APPLICATION NO. 04DRB-00141	PROJECT NO. 1003088
PROJECT NAME AIYARADO GARDENS No2.	
EPC APPLICATION NO.	
APPLICANT / AGENT DWANAWAY/WALLERSTEIN// <del>LAZAR</del> <sup>NORM</sup>	PHONE NO. 243-4400
ZONE ATLAS PAGE G-12	
(SDP for SUB), (SDP for BP), (FINAL PLATS), (MASTER DEV PLAN), (IR), (AA)	
<b>ONE STOP COMMENT FORM LOG</b>

**DEVELOPMENT REVIEW BOARD--SPEED MEMO**

**DRB CASE NO/PROJECT NO: 1003088**

**RE: Alvarado Gardens Unit 2/sketch**

A REPLAT OF THE EASTERLY ONE-HALF OF LOT 40
ALVARADO GARDENS UNIT NO. 2
WITHIN SE 1/4, SECTION 1, T.10N., R.2E., N.M.P.M.

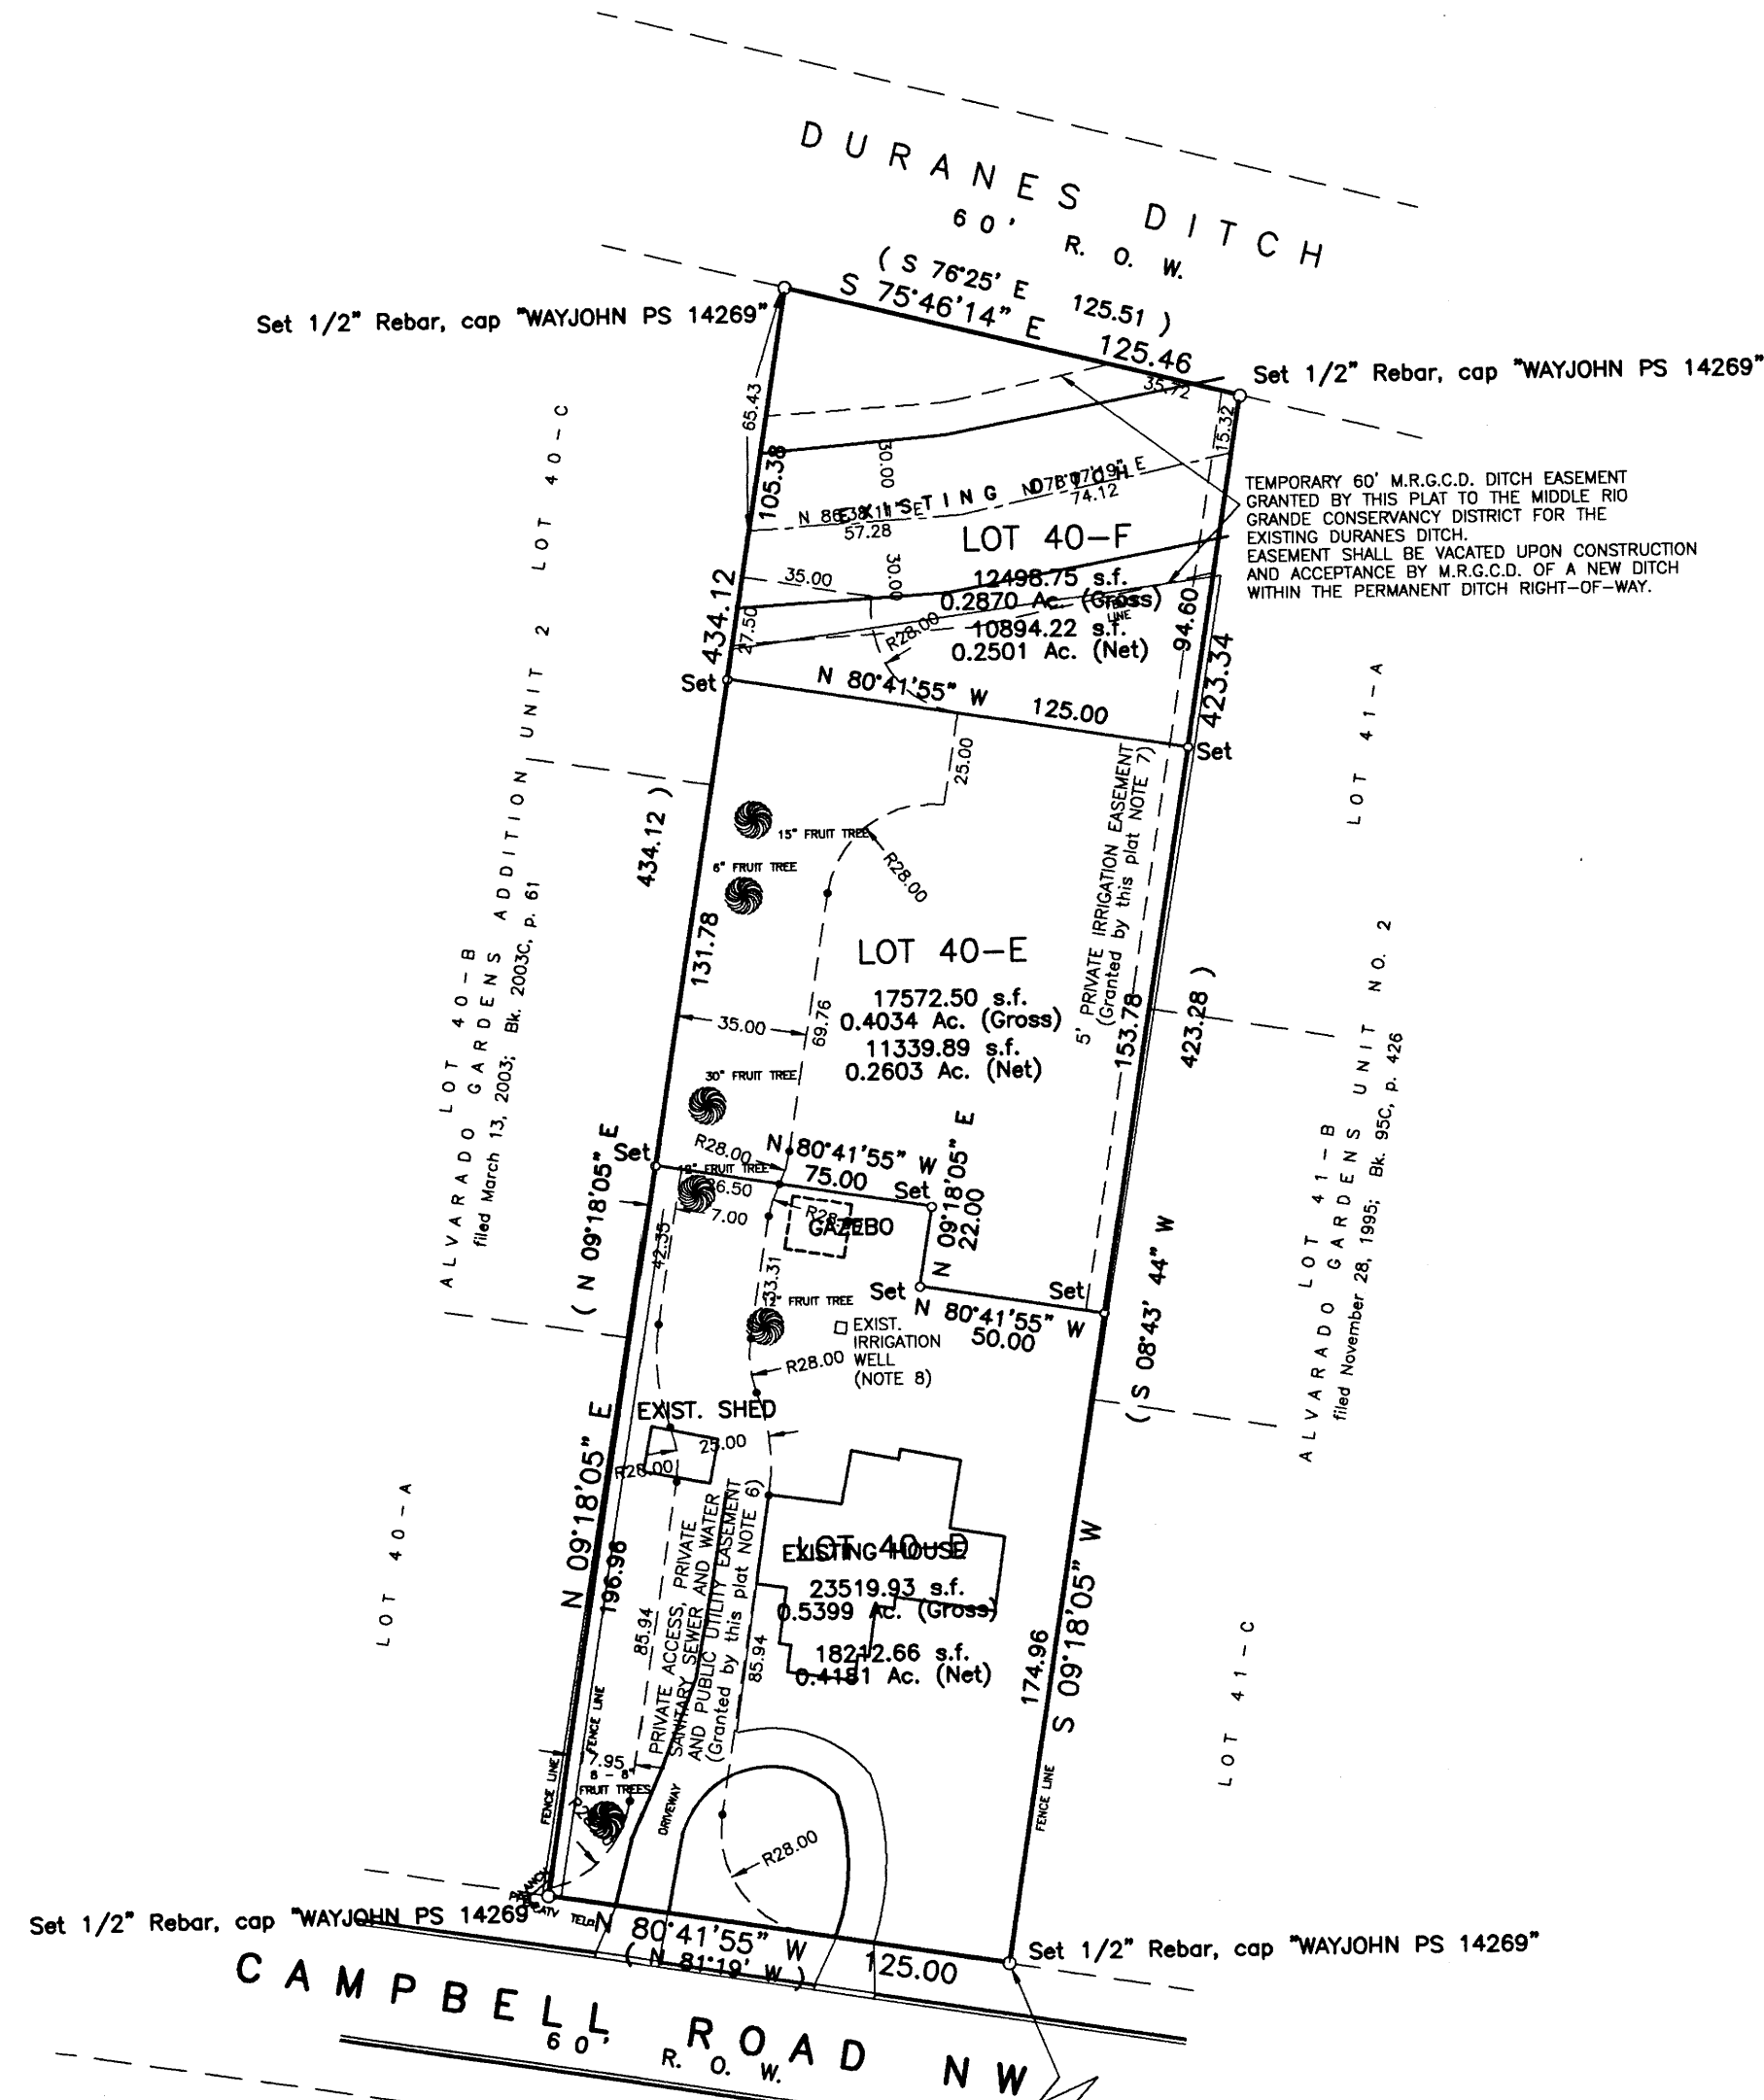
The third lot appears unbuildable?

No.	Comment
1	MINIMUM CLEAR EASEMENT NEEDS TO BE 22'
2	TURN-AROUND NEEDS TO BE APPROVED BY FIRE / SOLID WASTE
3	ROADWAY WILL NEED 6" DEEP FINISH 22' WIDE ENTRY (25') WILL NEED TO BE PAVED.
